In the Inspector's document 'Responses due by deadline 4: 22nd August there is reference to Sansoms Platt - the protected monument within the Northern Sector of the proposed Botley West Solar Farm.

Trial trenching results, Sansoms Platt

Title: Illustrative Masterplan
Figure 5.3: Cable Corridor Plan Overview - Area between the Northern and Central Sites on land to the east of Woodstock and in the vicinity of the Bladon roundabout on the A44

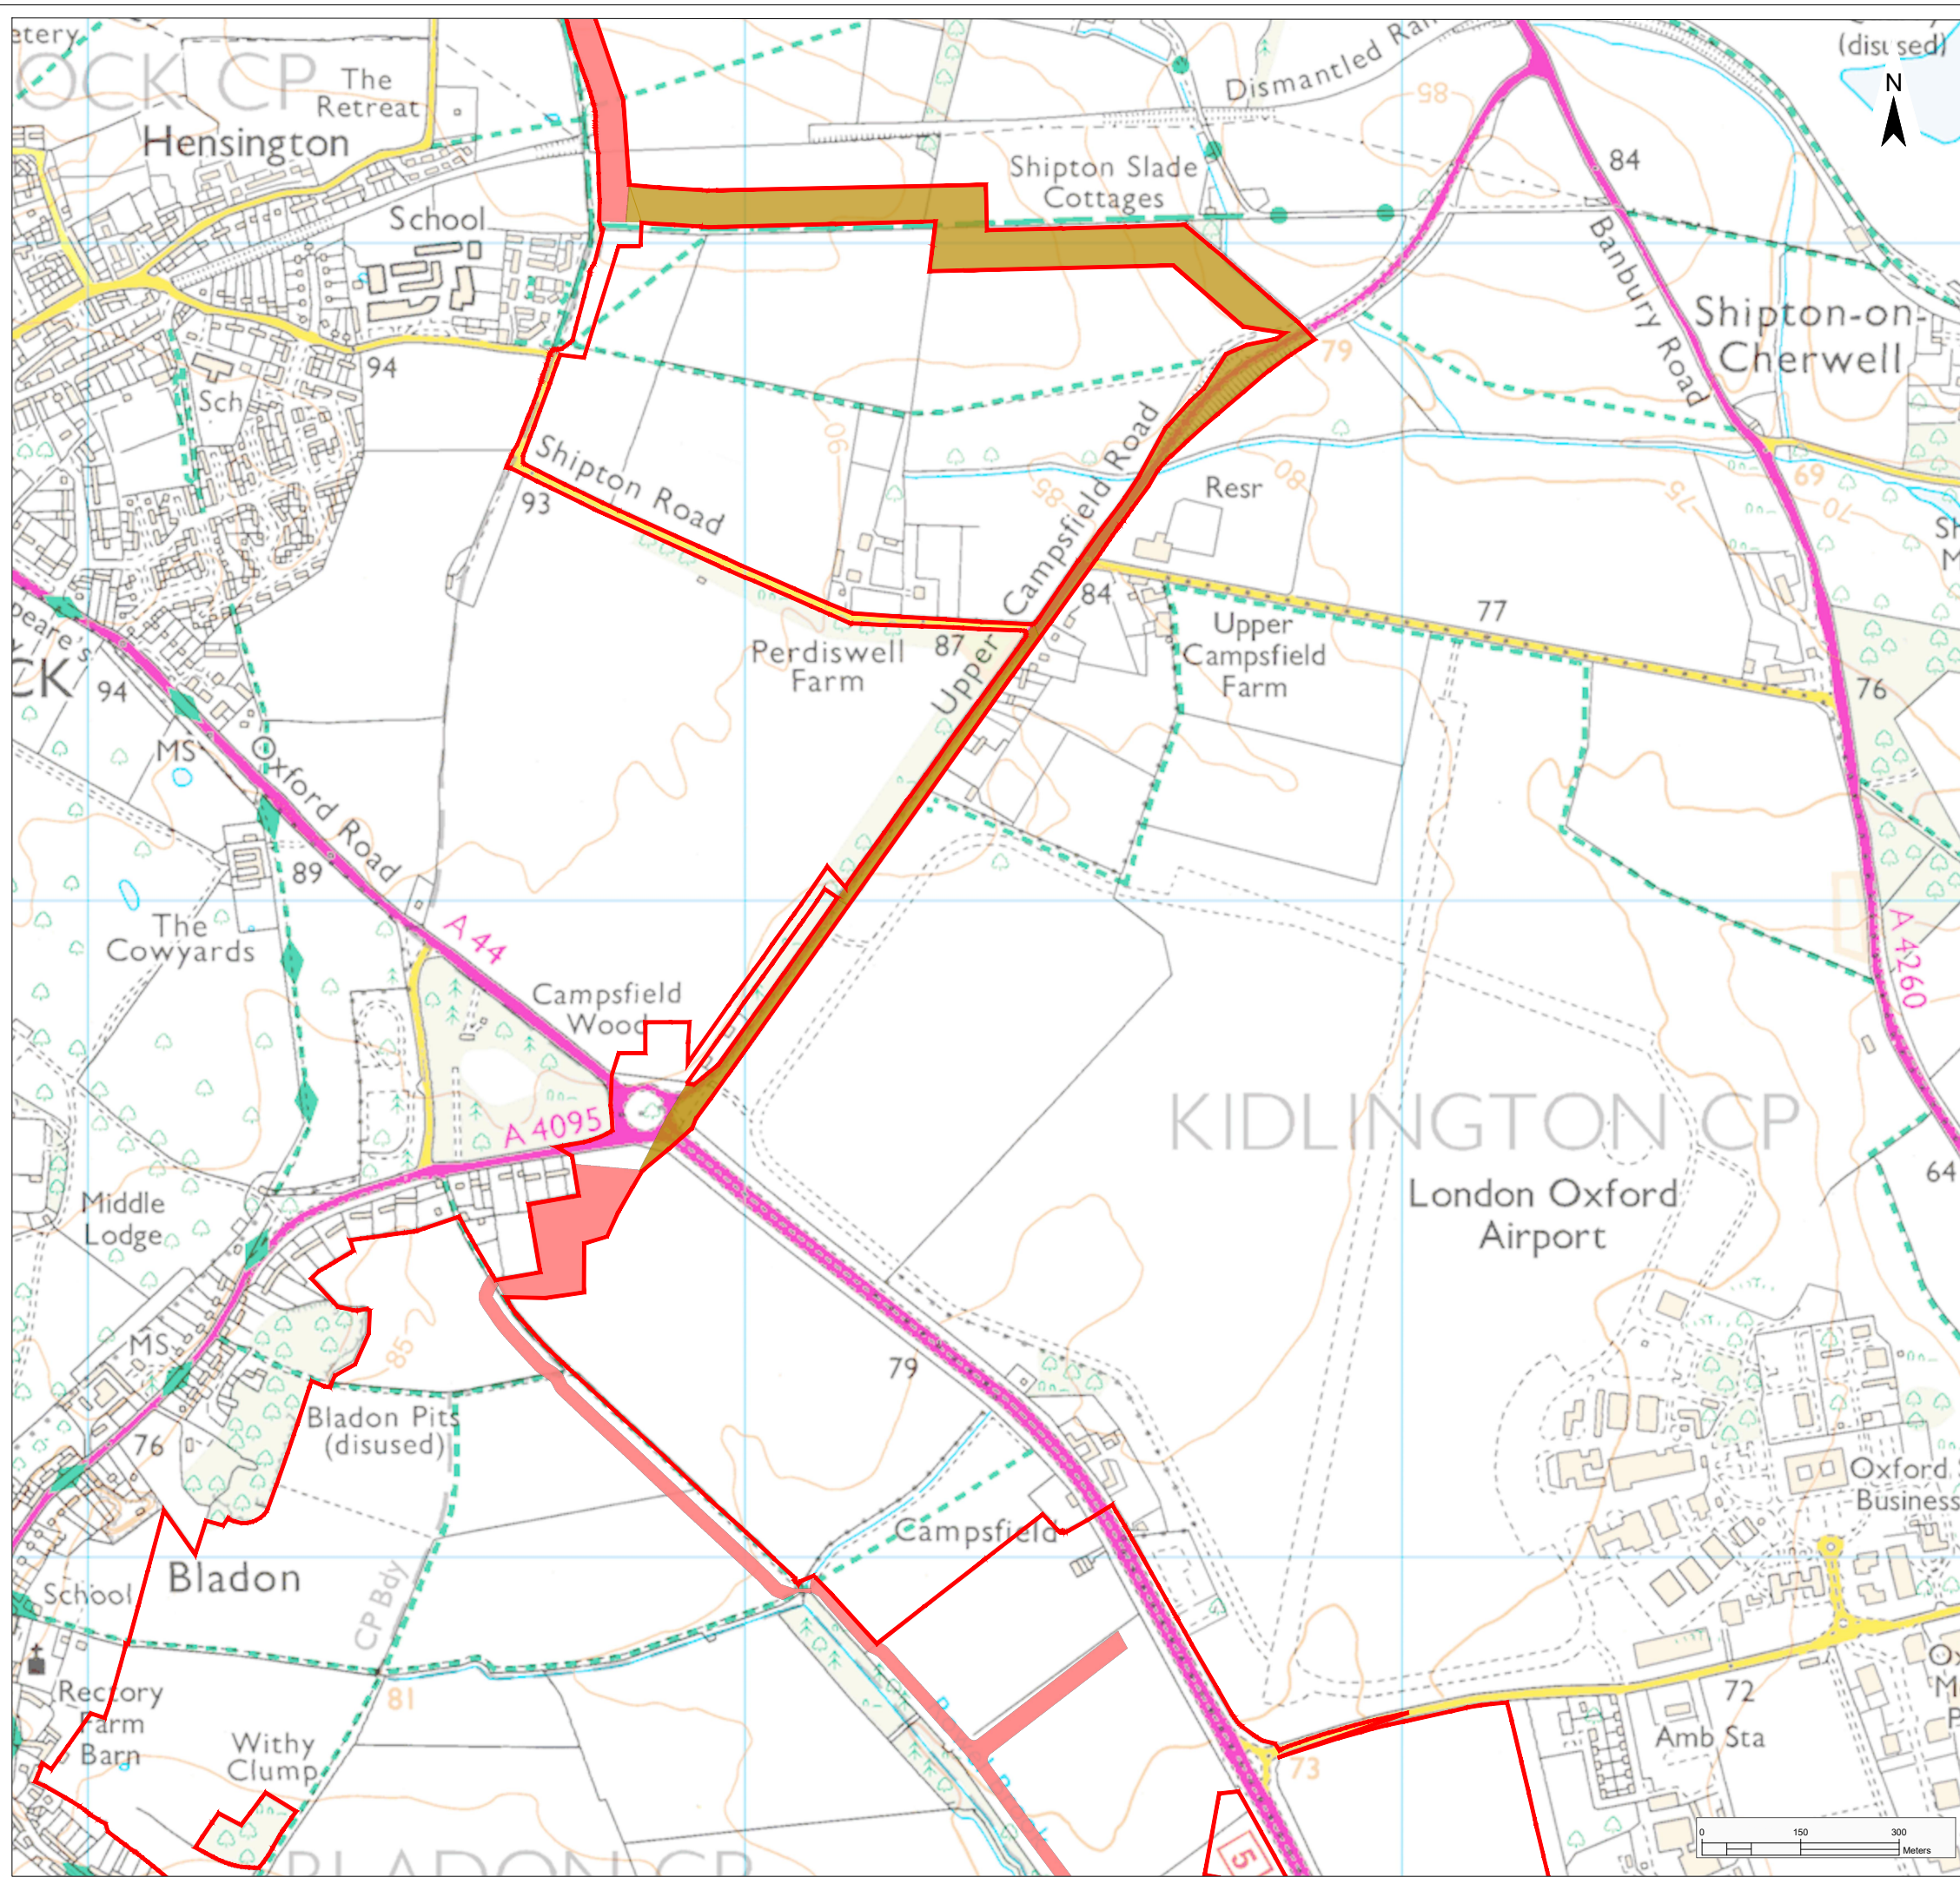
The developers intend to run their cables down this route which means they will dig right through this section of the Roman Town (field 1.11 which the developers have acknowledged contains Roman buildings following OCC's trenching and the red dots which indicate by Blenheim's ground radar more Roman buildings.)

It is beyond argument - this route cannot be used for cabling otherwise the developer is digging through a major part of the town which, at Sansoms Platt, is a protected monument
